KITITAS COUNTY

DEPARTMENT OF PUBLIC WORKS

MEMORANDUM

TO: All Staff
FROM: Public Works Planning Review Team
DATE: November 9, 2020
SUBJECT: BL-20-00023 Lawler

WEIS SHORT PLAT
A PORTION OF GOV'T LOT 3, SECTION 34
TOWNSHIP 21 NORTH, RANGE 14 EAST, W.M.,
KITTITAS COUNTY, WASHINGTON

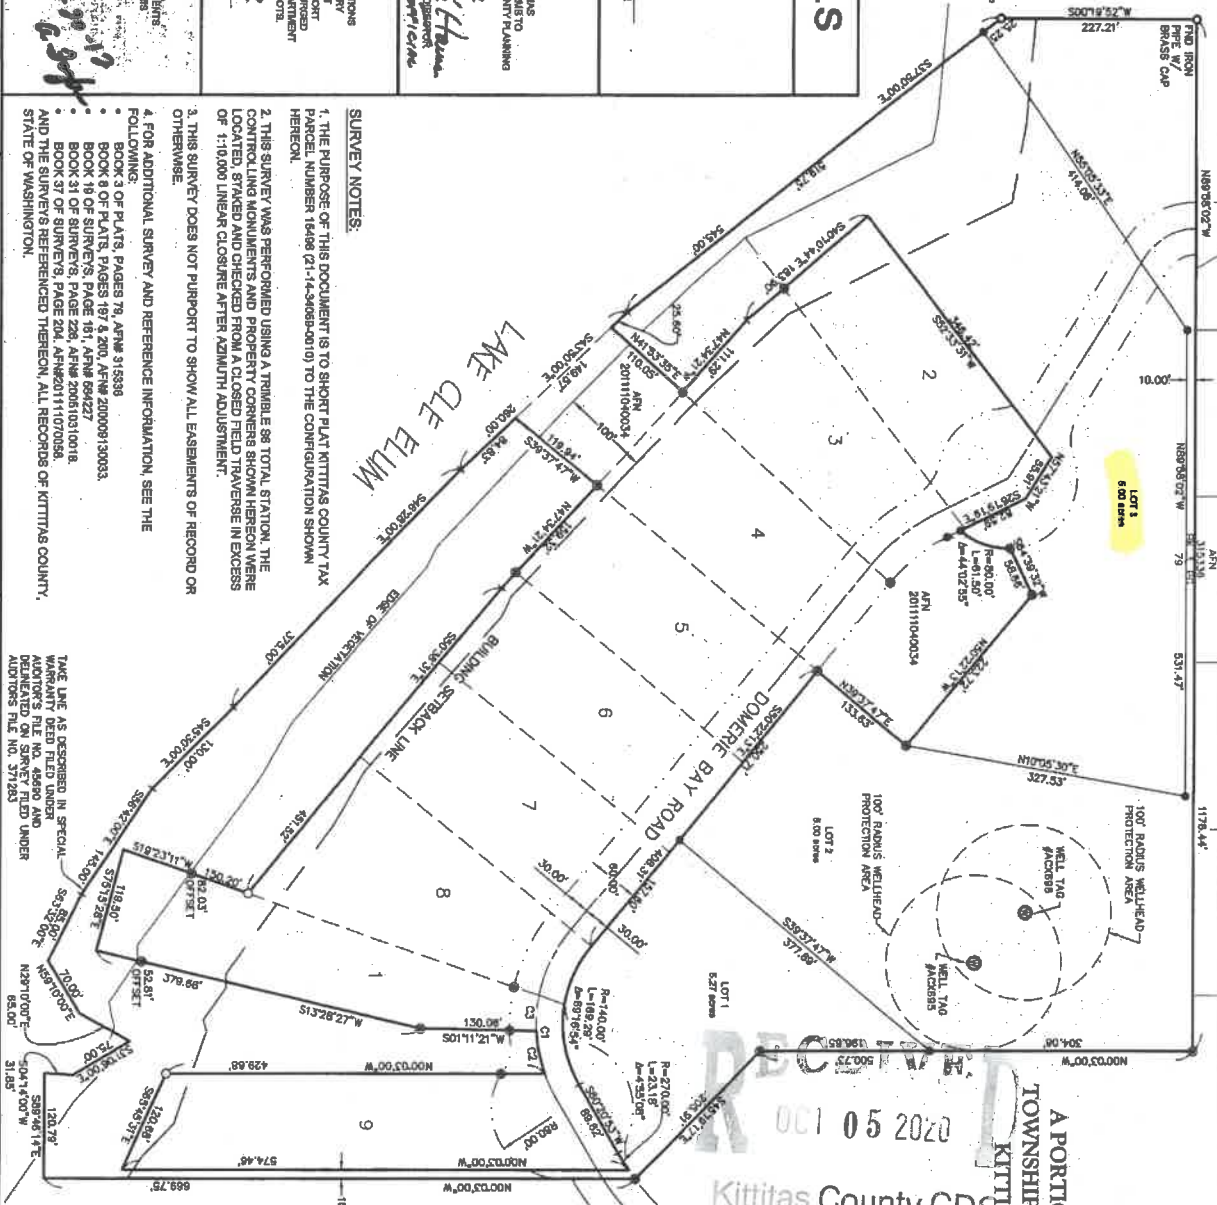
1. A survey map for review – the application map submitted is missing all the substantial data that would make it a survey. Any comments will be reserved until final.
2. Parcel 15489 to use existing address and access.
3. Parcel 957736 would need an access/address permit prior to building.

BOUNDARY LINE ADJUSTMENT BL-20-00023

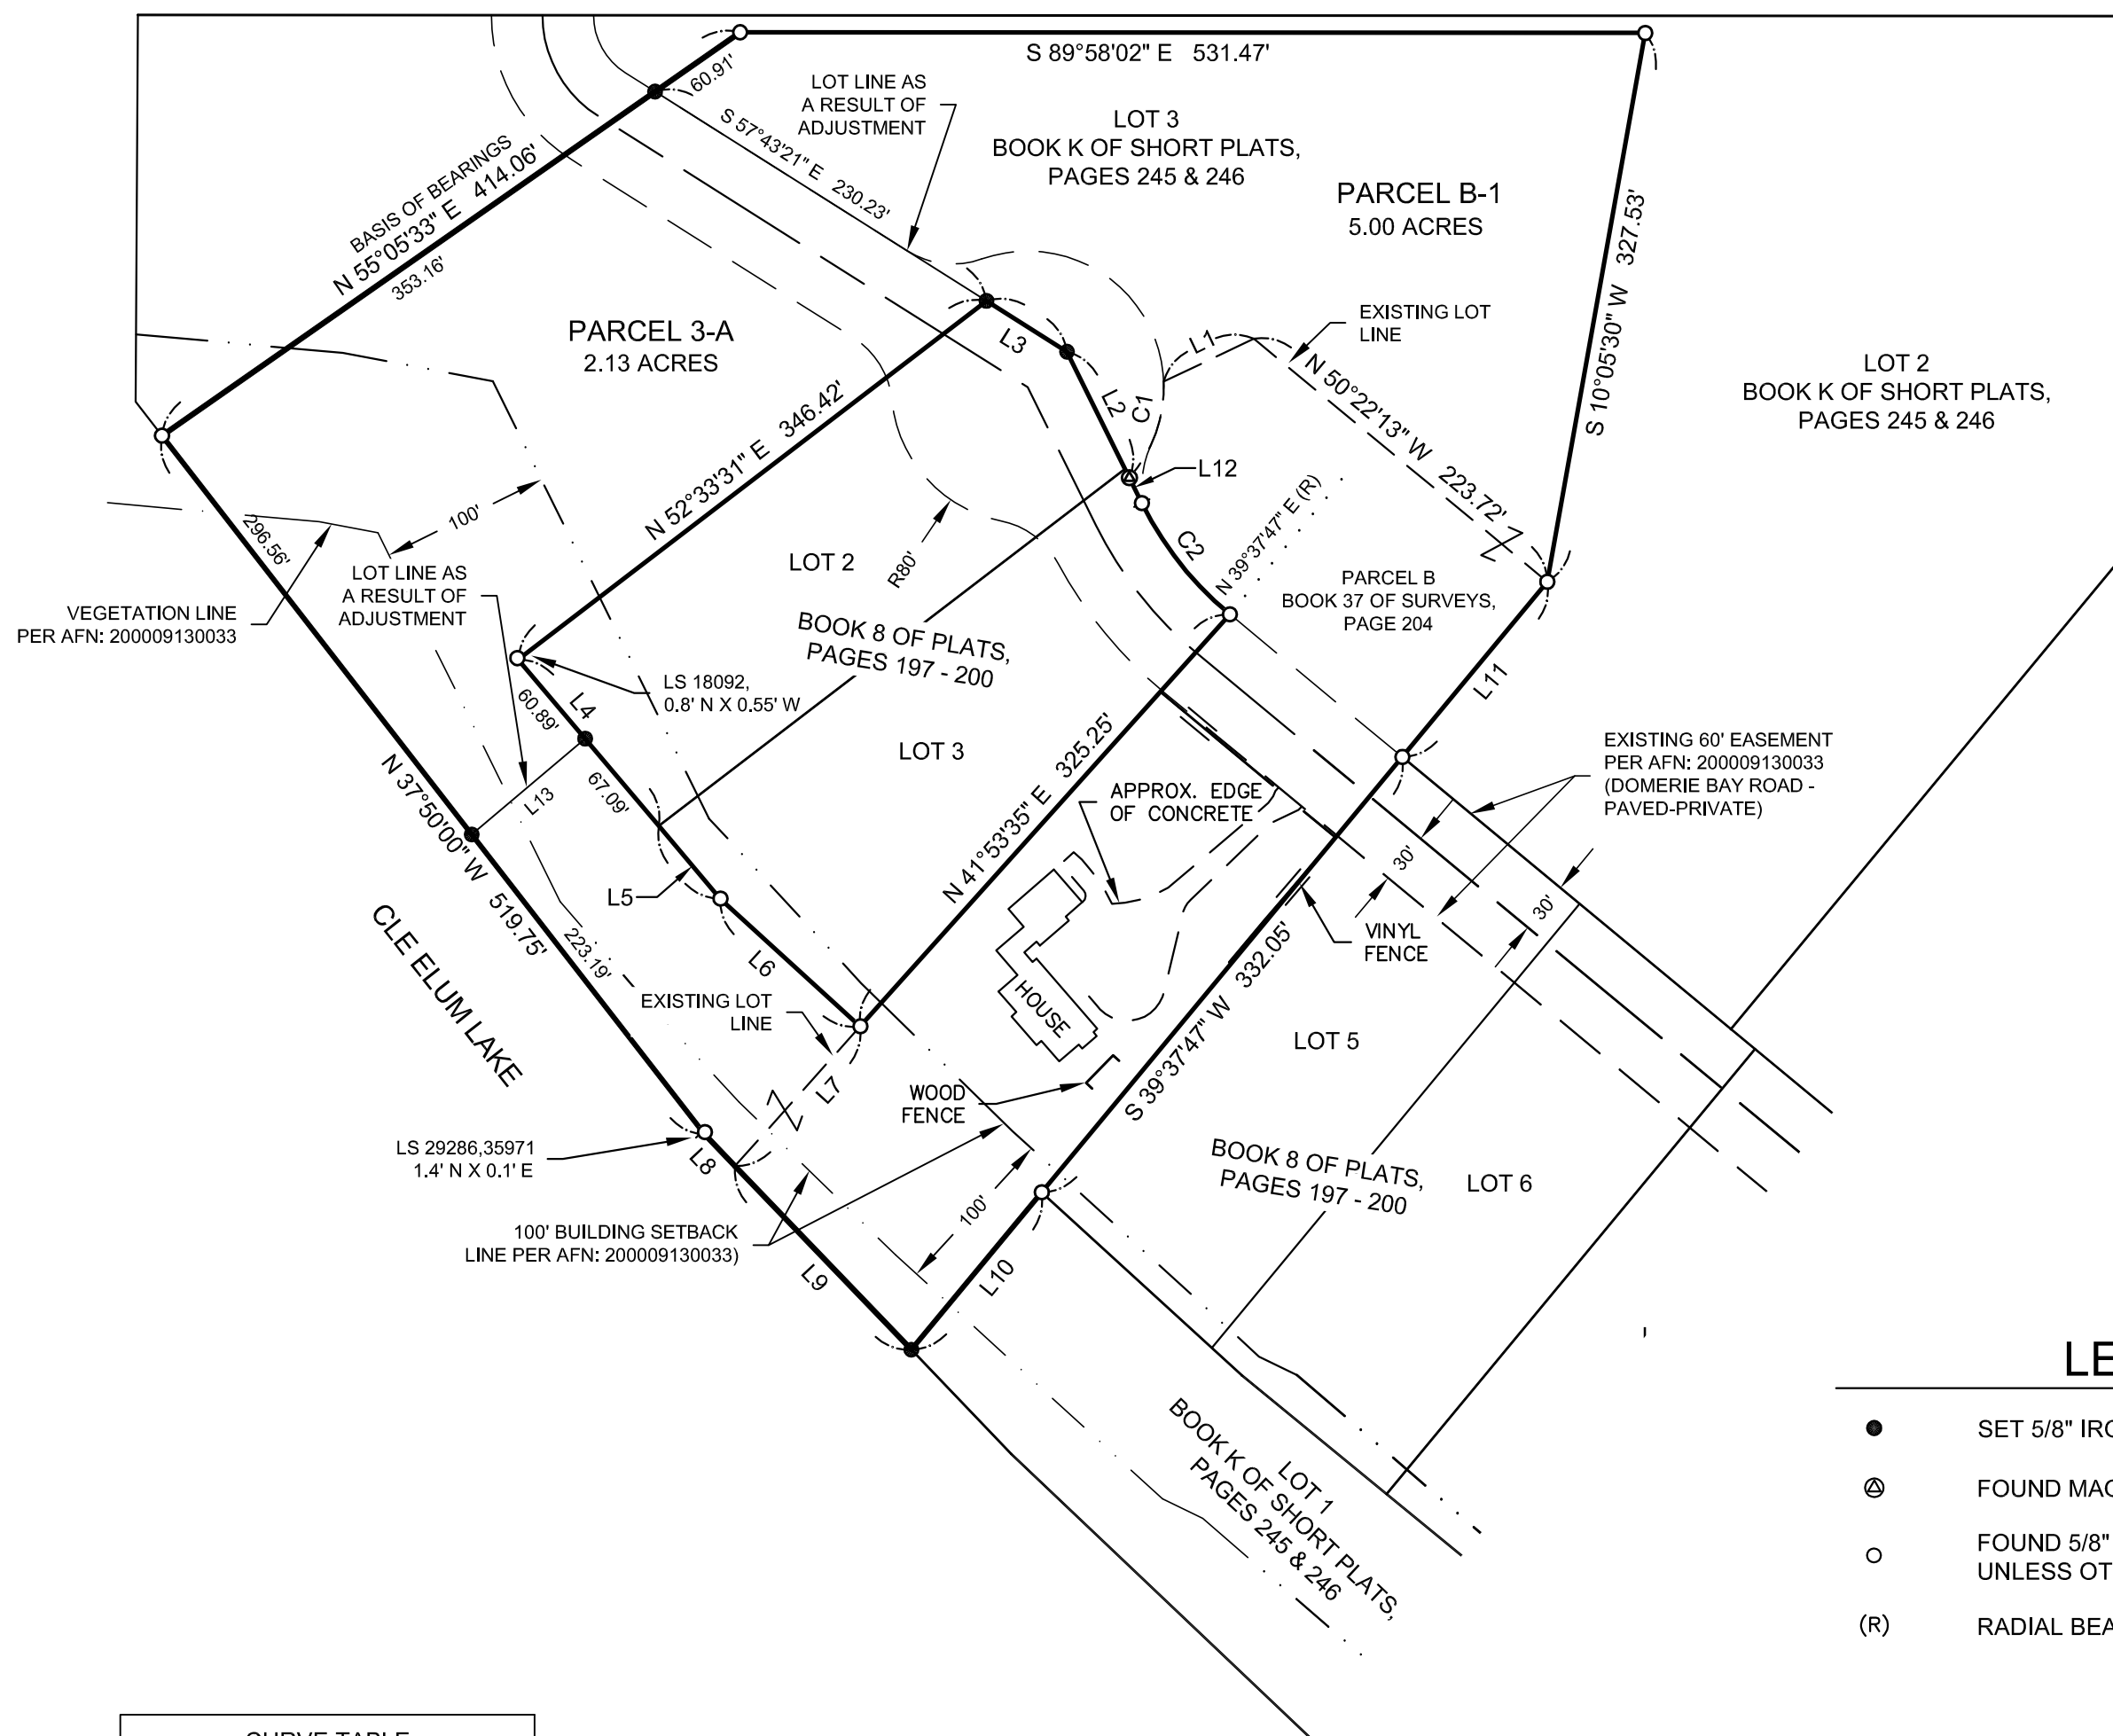
- a. Any access easements shall be shown on the face of the BLA.
- b. Maintenance of driveway approaches shall be the responsibility of the owner whose property they serve. The County will not maintain accesses.
- c. Any further subdivision or lots to be served by proposed access may result in further access requirements. See Kittitas County Road Standards.
- d. Evidence of existing access and/or evidence of access to be created should be confirmed prior to sale of property.
- e. Access is not guaranteed to any existing or created parcel on this application.
